# Department for Transport

### **Application by Highways England (“the Applicant”) for an Order granting Development Consent for the A303 Sparkford to Ilchester Dualling.**

#### **REQUEST FOR COMMENTS FROM THE APPLICANT AND OTHER ADDRESSEES ON THE APPLICATION FOR THE PROPOSED A303 SPARKFORD TO IICHESTER DUALLING.**

FIGURE 2.5  
HAZLEGROVE JUNCTION UNDERBRIDGE  
GENERAL ARRANGEMENT

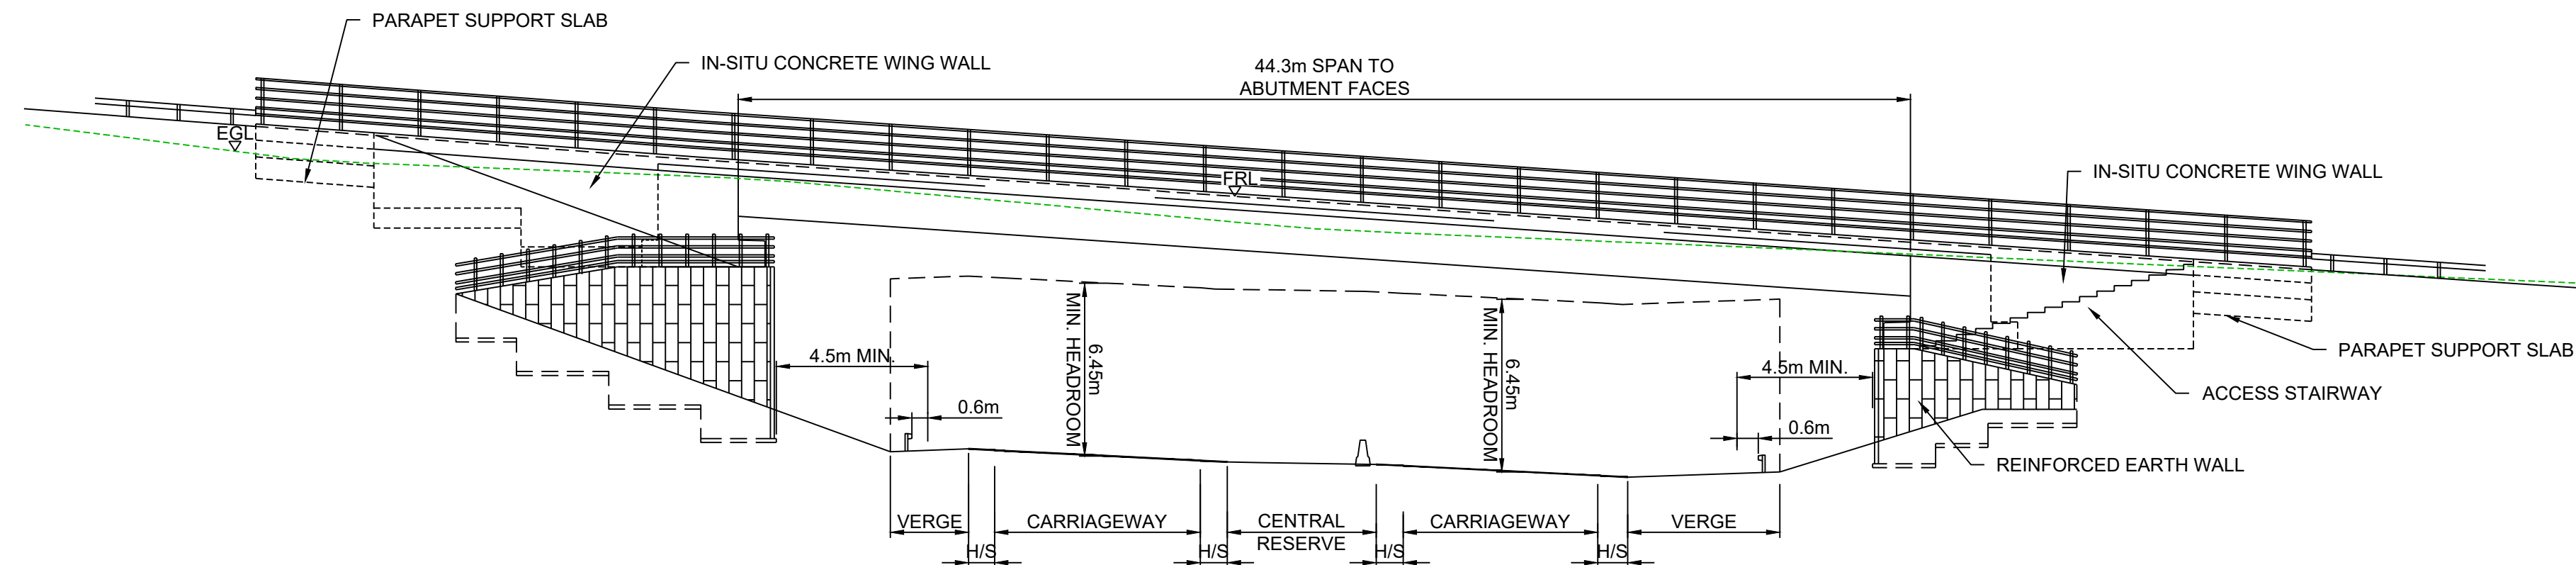
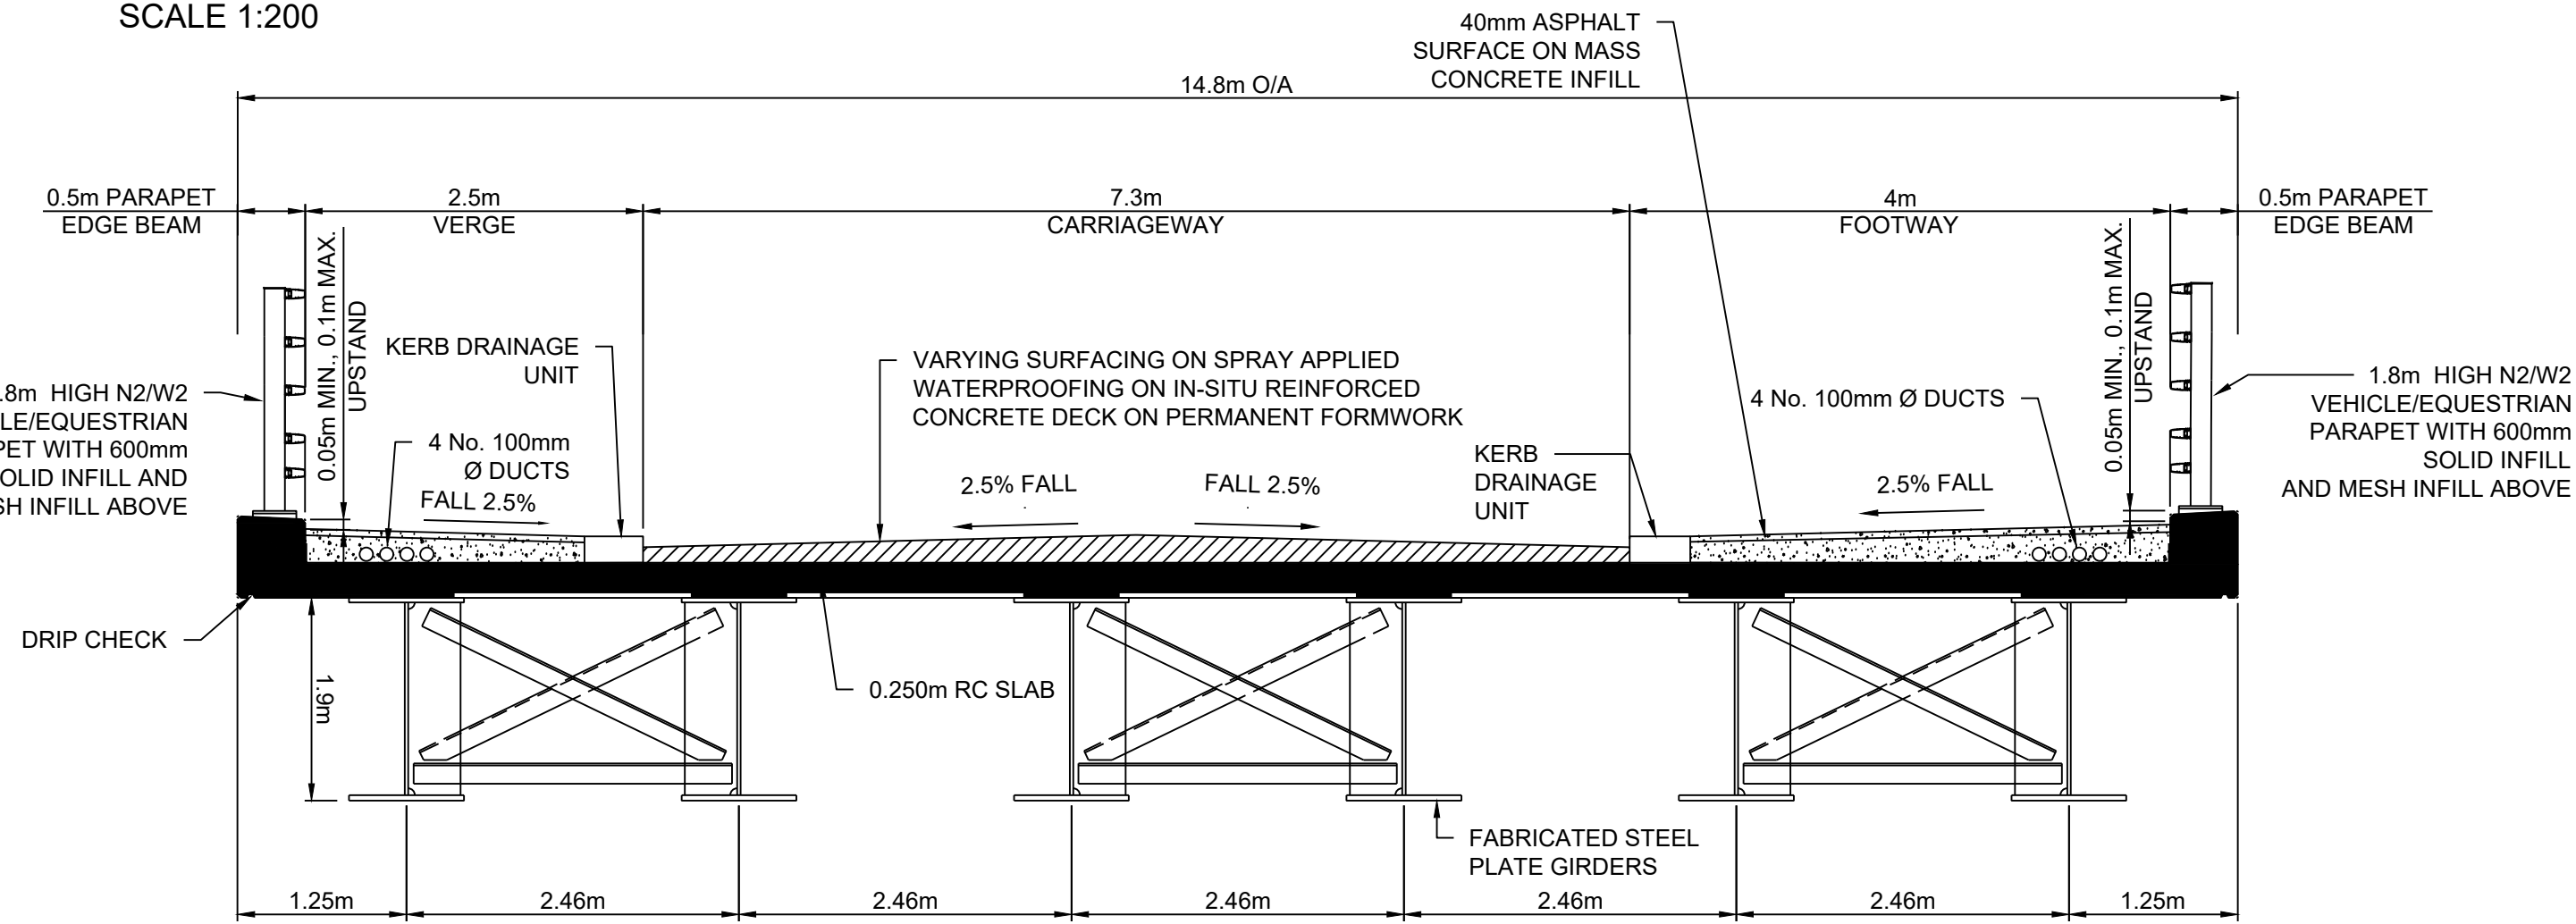
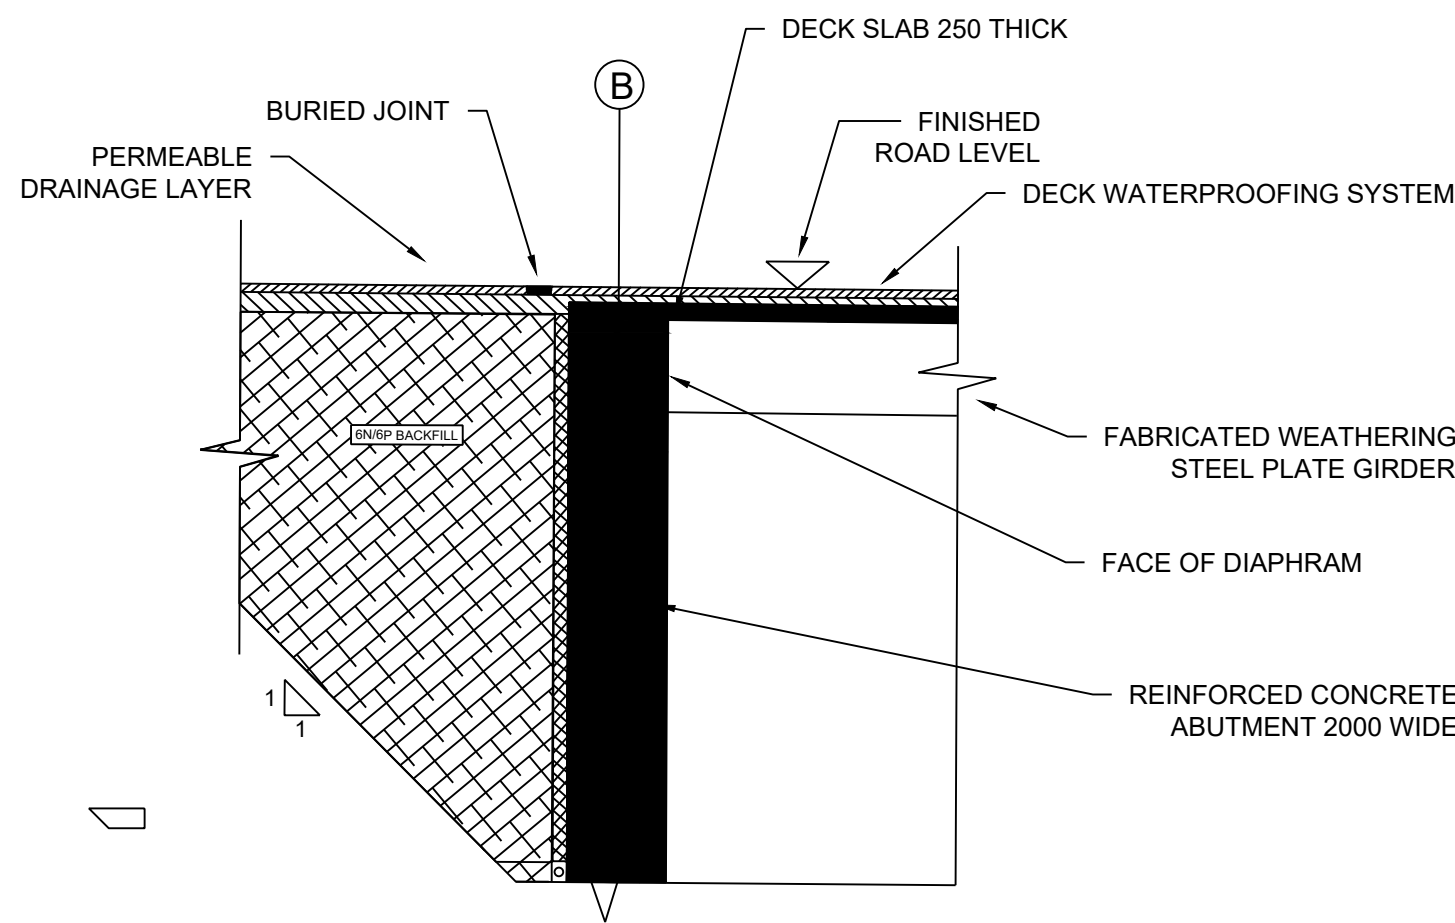
The Secretary of State requests an update from the Applicant regarding the provision of a west bound route for NMUs, as suggested by SCC. In particular, the Secretary of State requests an update from the Applicant regarding the possibility of upgrading the Higher Farm Lane Bridge.
